**KIRKLEES METROPOLITAN COUNCIL  
INVESTMENT & REGENERATION SERVICE**

<b>Reference No:</b>	2025/44/93086/W
<b>Site Address:</b>	Wappy Springs Inn, Lindley Moor Road, Lindley Moor, Huddersfield, HD3 3TD
<b>Description:</b>	Discharge of details reserved by condition 21 (fence) on previous permission 2024/92553 for erection of mixed industrial development (Use Classes E(g)(ii, iii), B2 and B8); including demolition of existing structures, new yard, parking, landscaping, drainage features and ancillary structures
<b>Recommending Officer:</b>	Ellie Thornhill

**DECISION – Discharge of Condition – Approve**

**Application:** 2025/93086

Drawing Title
FENCING & GATE DETAIL DoC

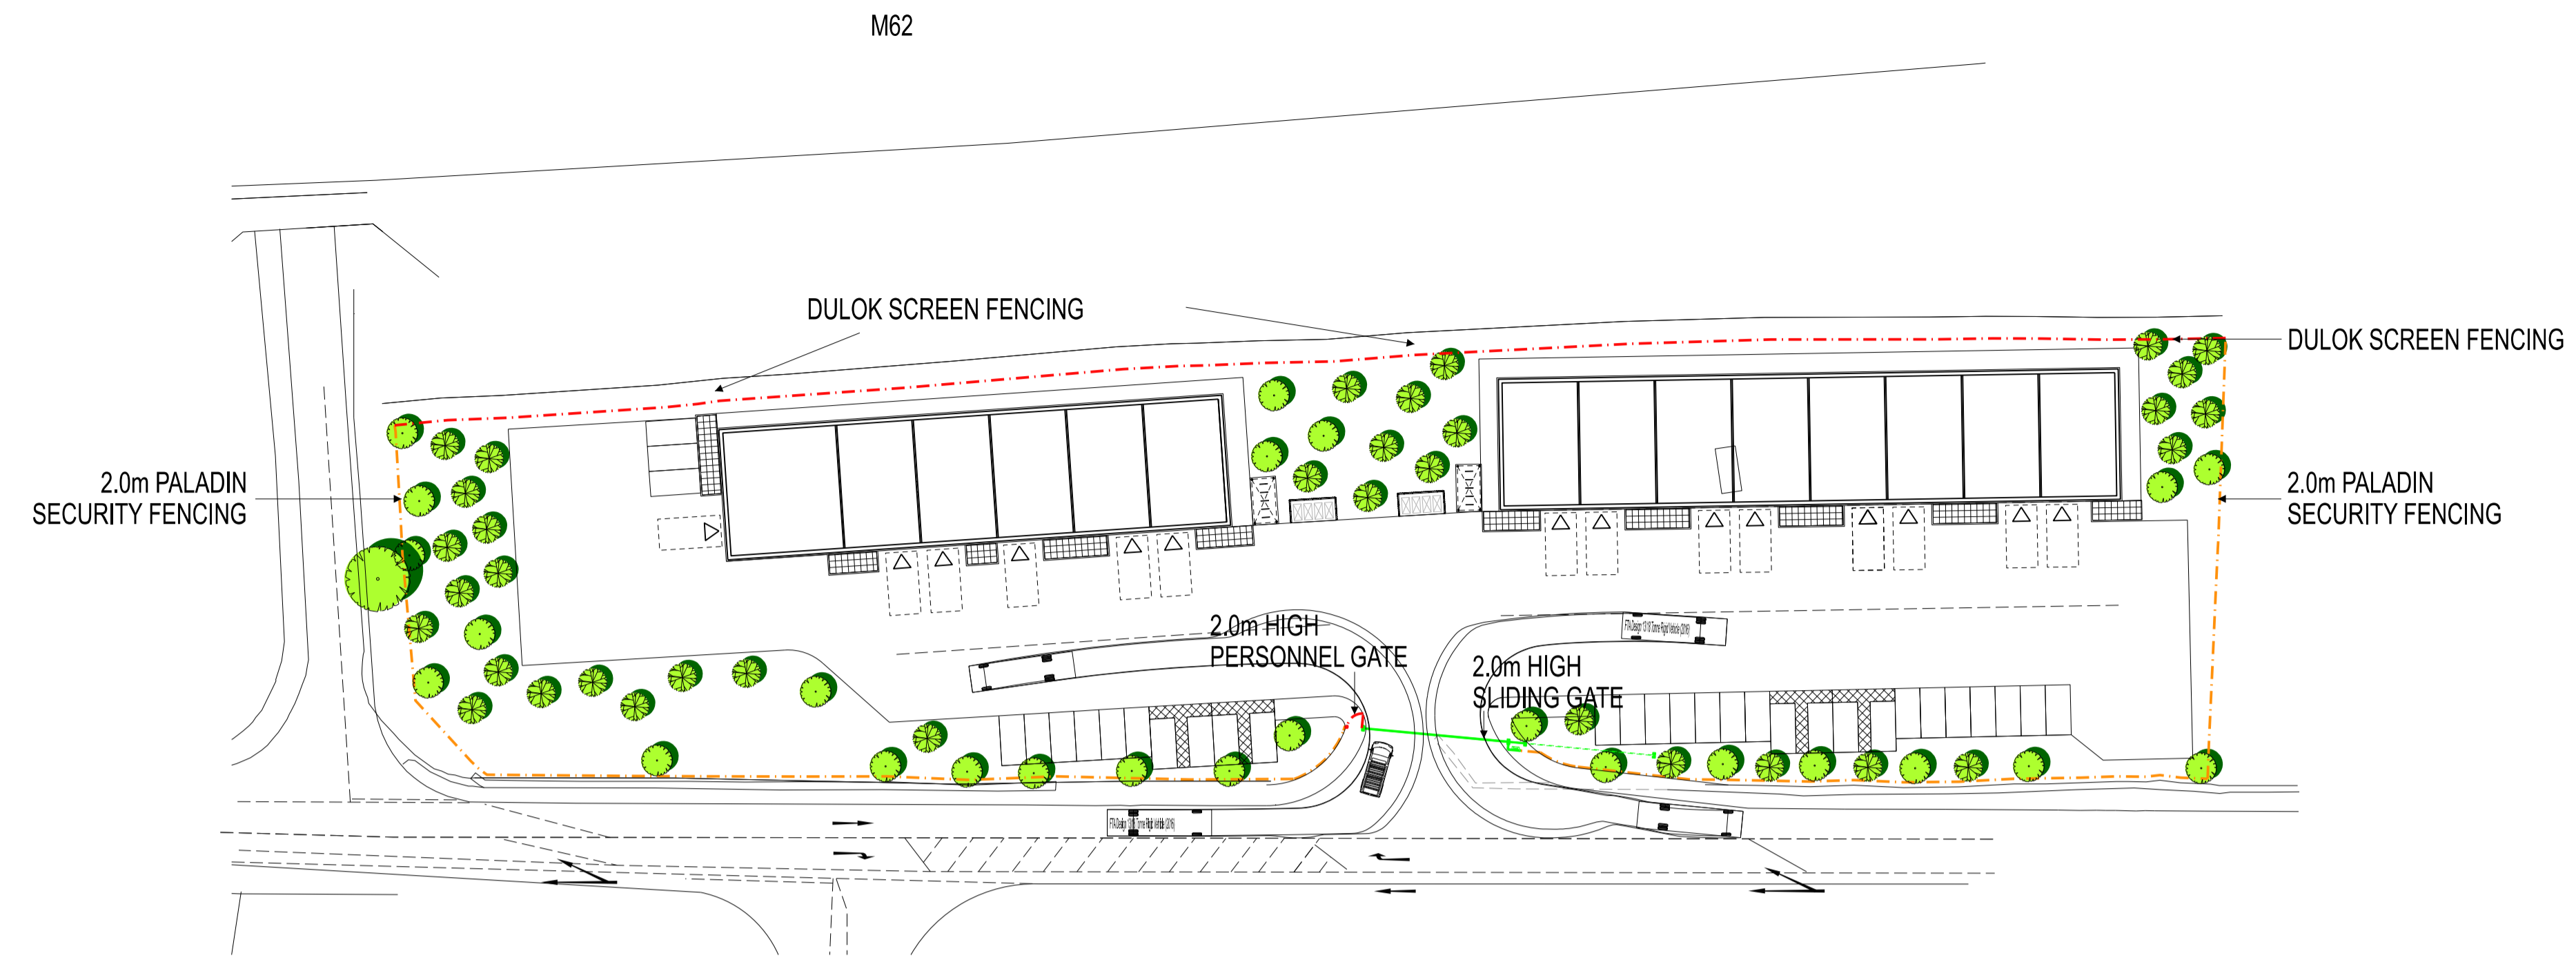
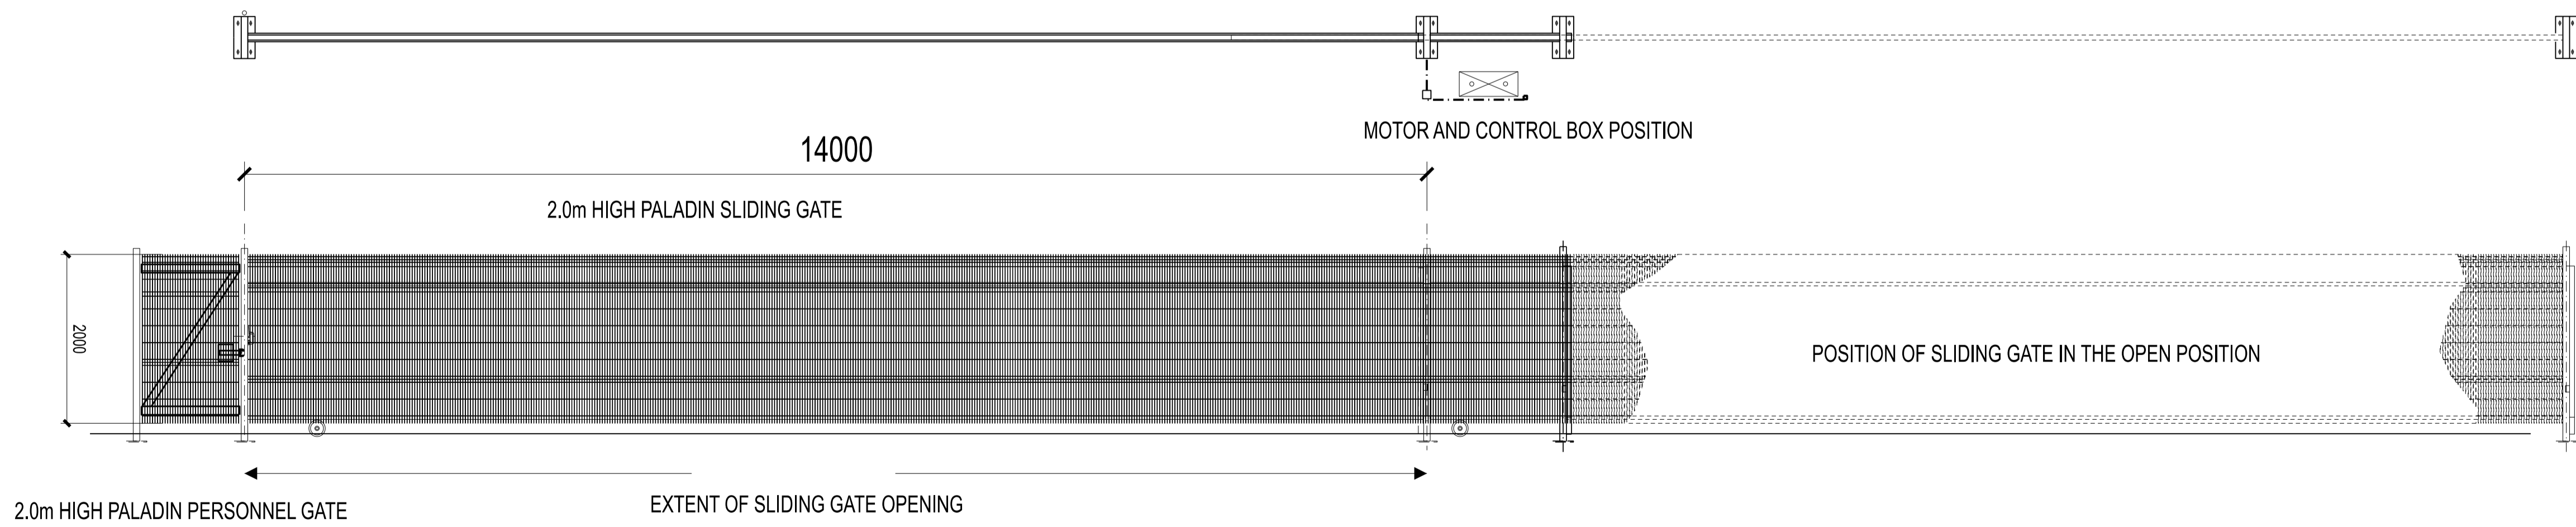
*However, a plan showing the alignment of the fence along the boundary of the development site with the M62 (or at least one metre from any part of the existing Motorway fence where the boundary lies within one metre of this) has not been provided as required.*

*Thank you for providing the drawing which I see includes the fence adjacent to the M62 although it does not include measurements to satisfy me that it will be erected at least one metre from any part of the existing Motorway fence where the boundary lies within one metre of this.*

Considering the above, Planning Officers concur with the assessment made by National Highways, including regarding the separation distance from the fence, and recommend that the submitted details can be approved.

**Please note:** You are also reminded that the condition states that the fence should be erected at least one meter away from the existing Motorway fence where the boundary lies within one metre of this. Officers have only assessed the location and details of the Dulok Screen Fence required by condition 21.

*Notwithstanding this, I see no merit in requesting a revised drawing as the applicant is obliged to adhere to the requirements of the condition, as such I offer no objection to the discharge of this condition.*
